EL PASO COUNTY GRADING AND EROSION CONTROL PLAN CHECKLIST

EPC Project Number: **SP-21-001 (typical all pages)**

DESIGNED BY: JUM DATE: 01.16.21		DRAWN BY: JUM DATE: 01.16.21		CHECKED BY:		DATE:	
SCALE: N/A		HORIZ: N/A		VERT: N/A		STATION:	
						FROM:	
						TO:	
FALCON FIELD		GENERAL NOTES					
REVISIONS:		DATE					
NO. DESCRIPTION							
PROJECT NUMBER:		2303					
SHEET		OF					
2		5

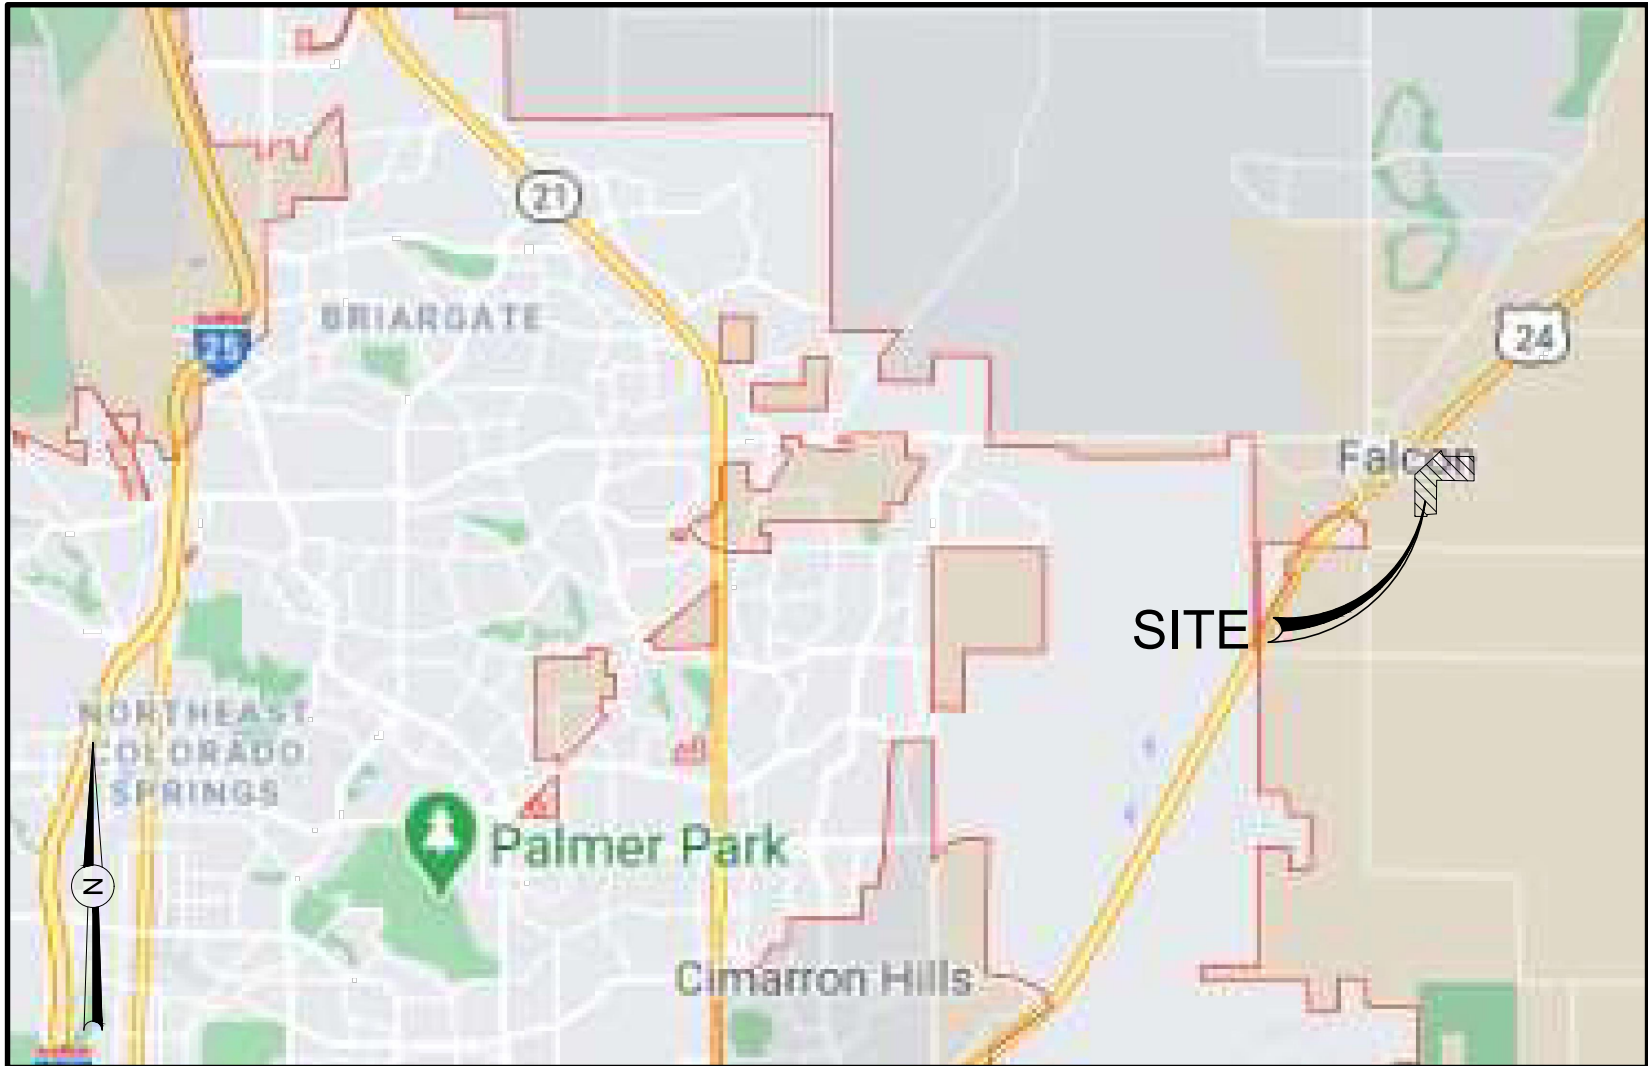
If needed, discuss under what circumstances in plan notes. And talk to State about the need for a dewatering permit. Or if not needed, discuss in notes how shallow groundwater encountered will be dealt with and protected with BMPs. (soils report says that dewatering will likely be needed)

See note on top of sheet 2 of GEC Plan
